CITY OF ALBUQUERQUE

Re: Route 66 Storage

99999 Central SW (Central & 98th st SW)

Conceptual Traffic Circulation Layout for DFT Approval

<p>ENGINEER'S SEAL</p>		ROUTE 66 STORAGE ALBUQUERQUE, NM	DRAWN BY AS
		TRAFFIC CIRCULATION LAYOUT	DATE 02/13/25
			2022105_TCL
			SHEET # <b>TCL</b>
<p>RONALD R. BOHANNAN P.E. #7868</p>			JOB # 2022105

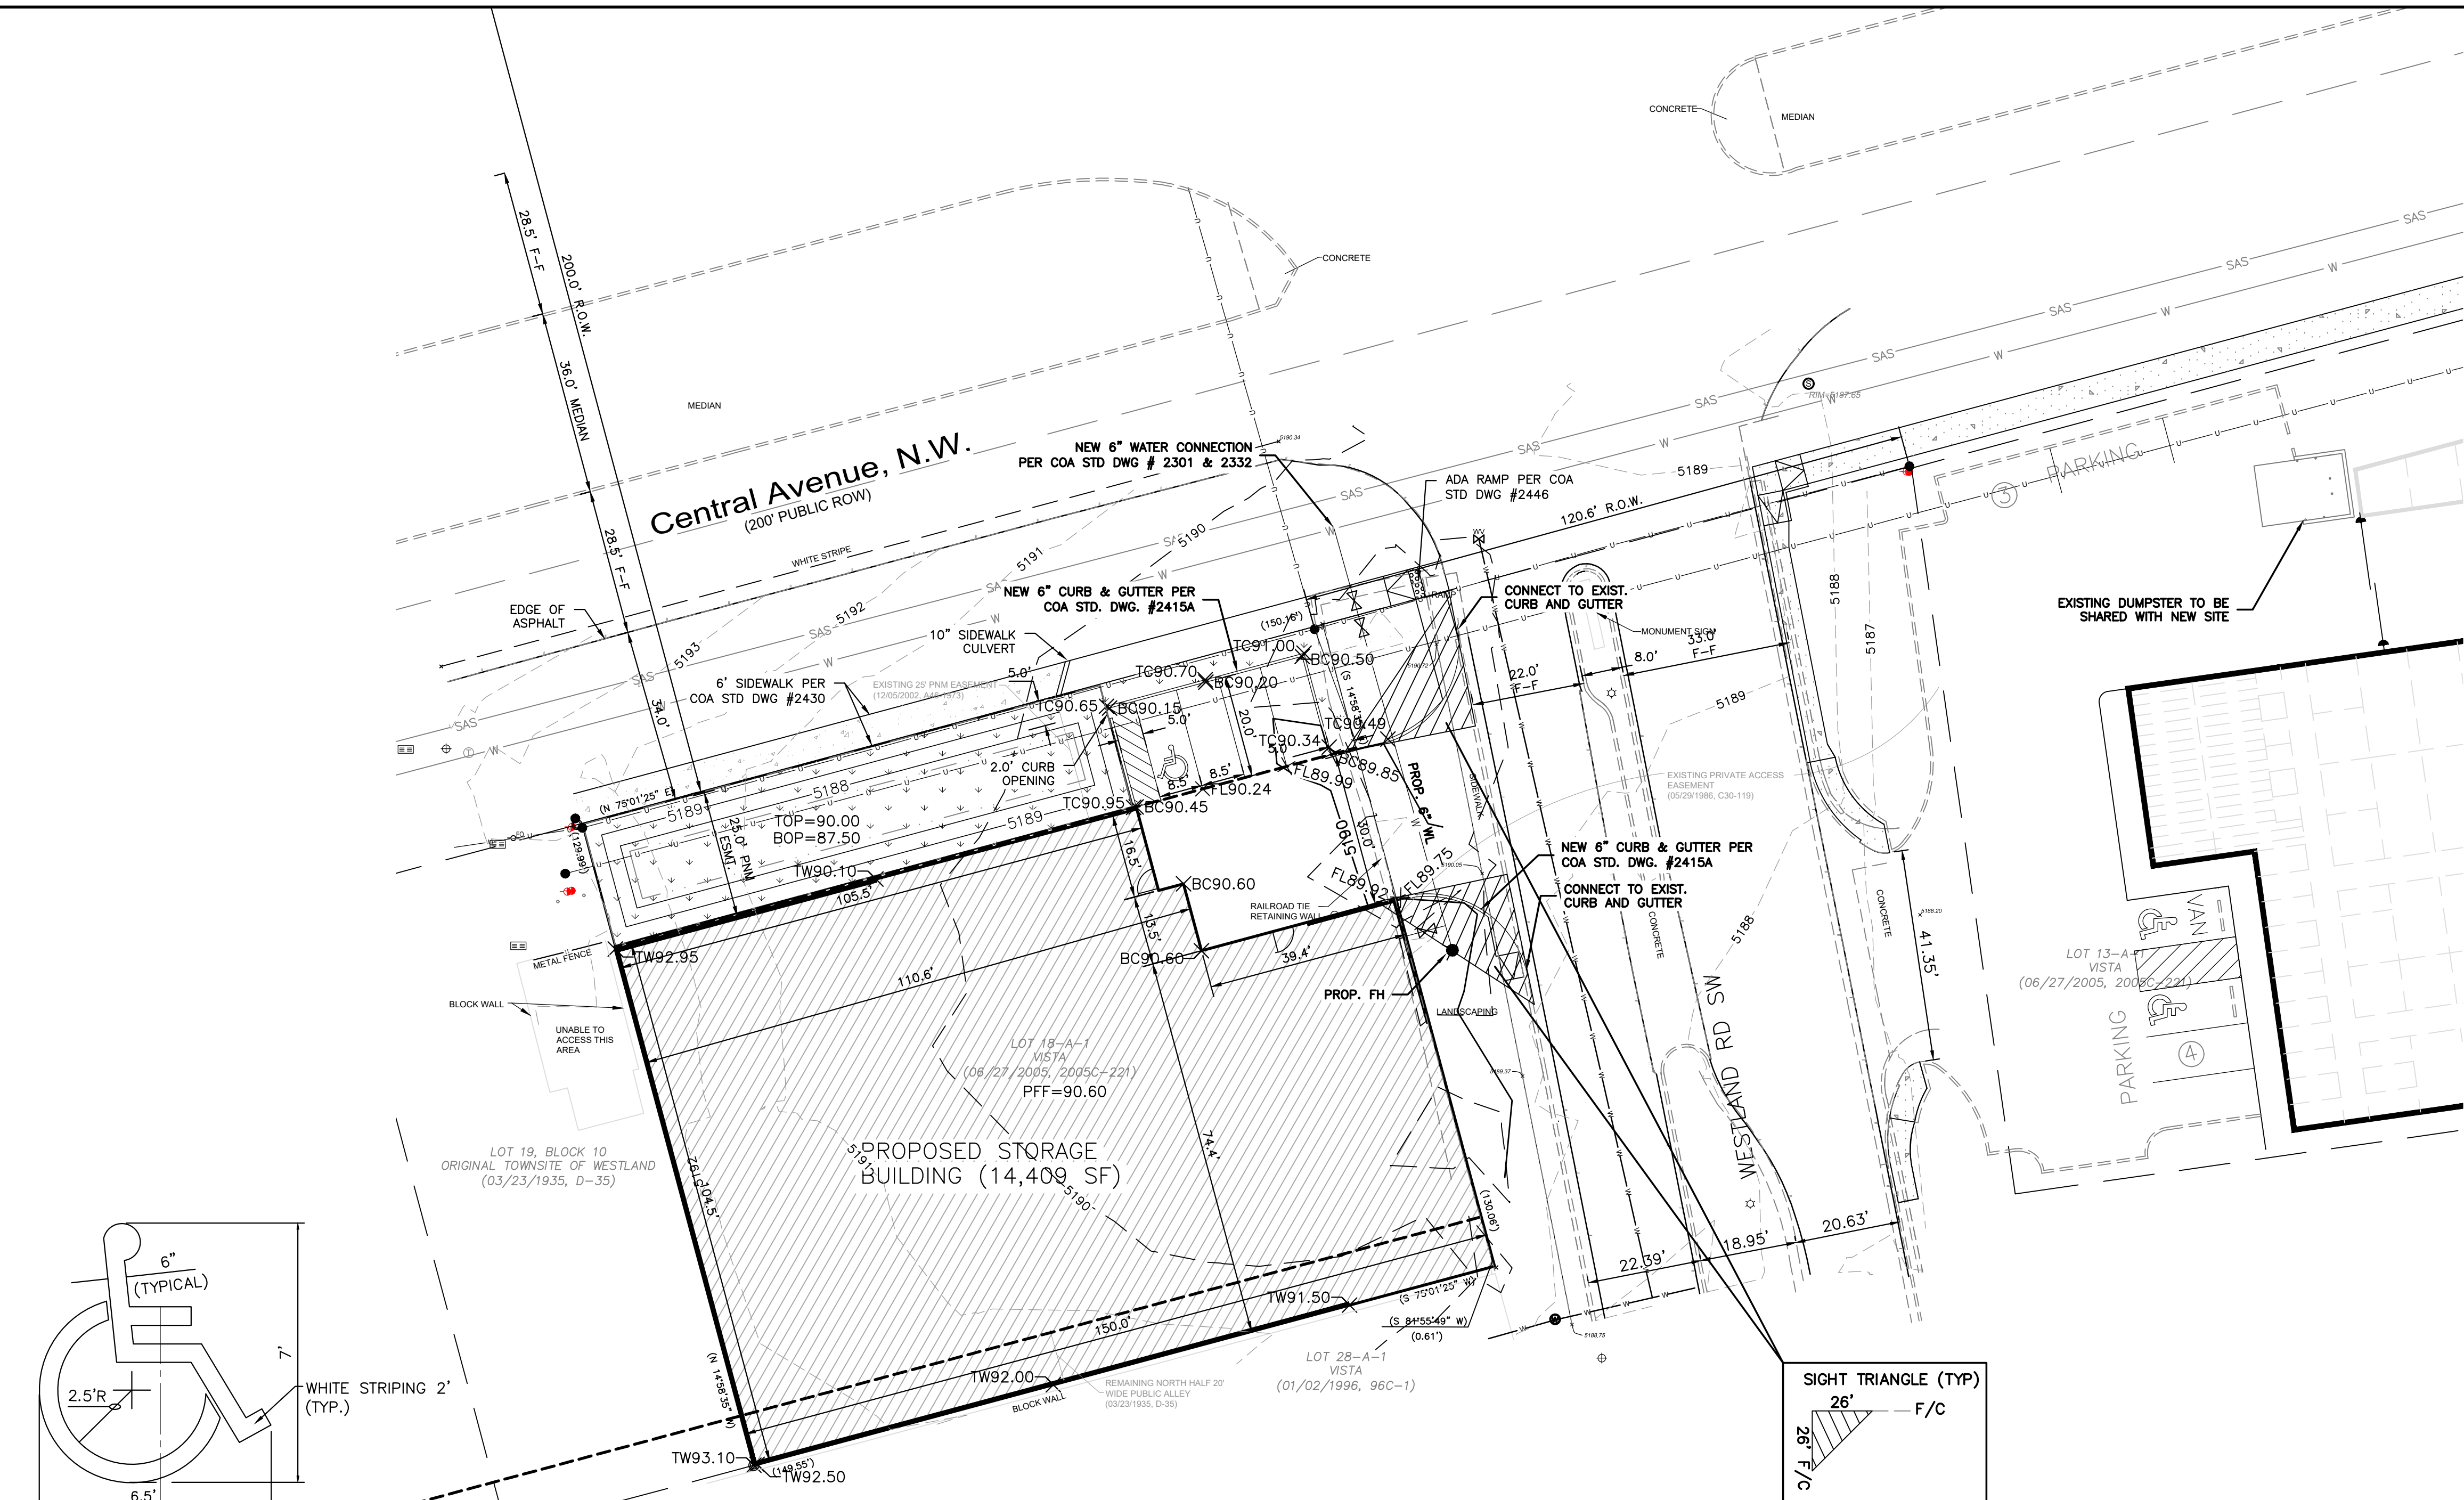
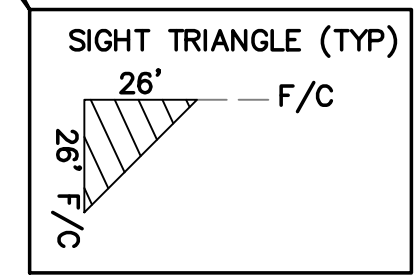
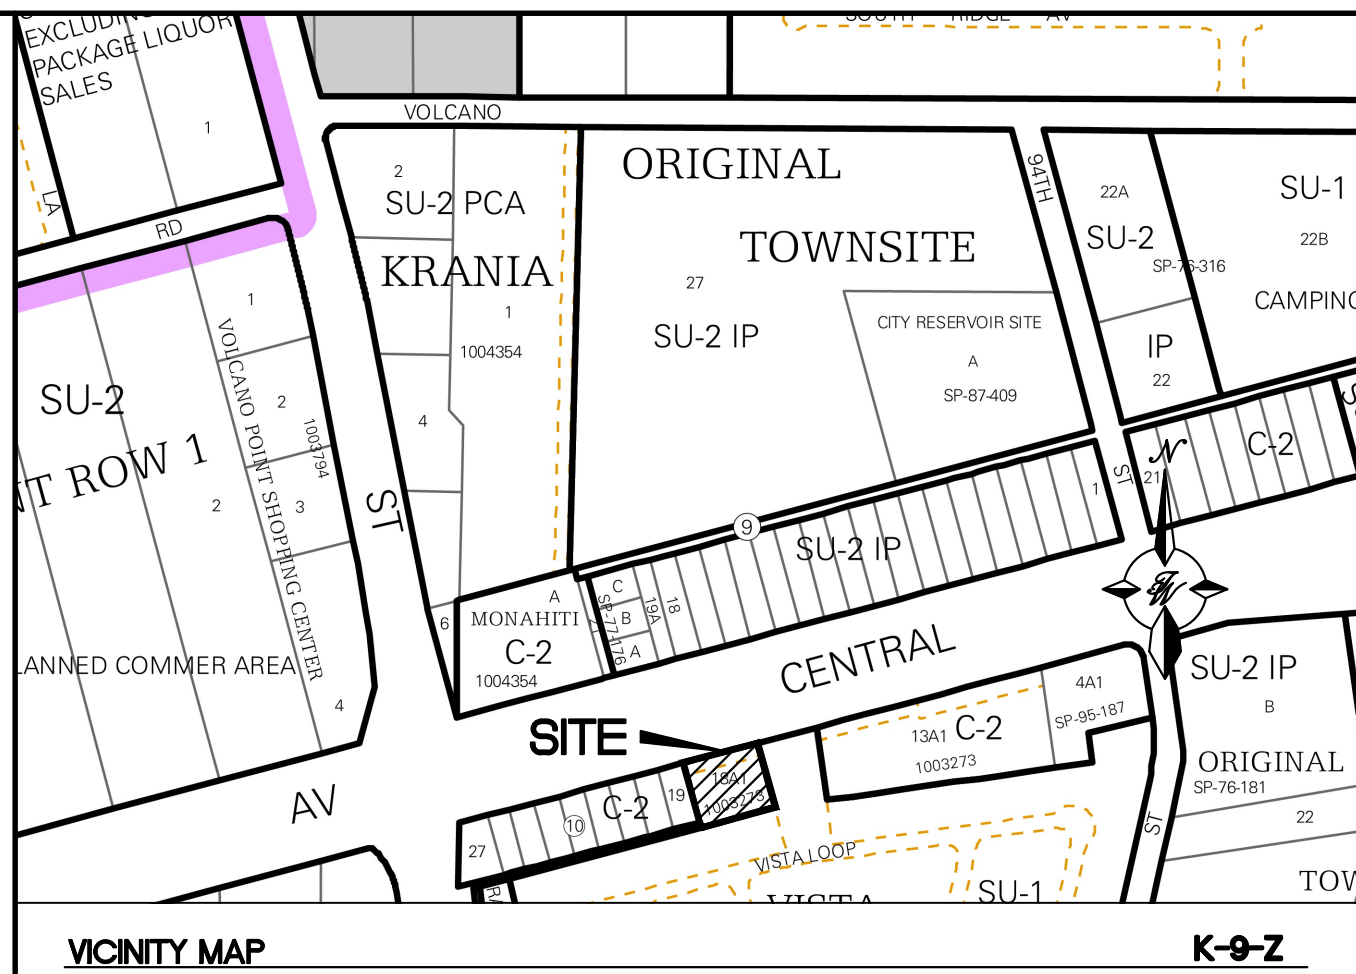
1-Van access aisle is 8 ft wide (not 5')

2-Add one Motorcycle parking space and two Bike Racks

3-Add two ADA sidewalk ramps with truncated domes at the entrance

4-Replace the COA STD. DWG #2415A by 2415C

5-Add ADA path from ADA parking to the building

6-Remove all the features from the drawing that are not TCL related.

7-Boundary line is clear

8-Show the width of sidewalk along Westland Rd. It should be a minimum of 5 ft wide
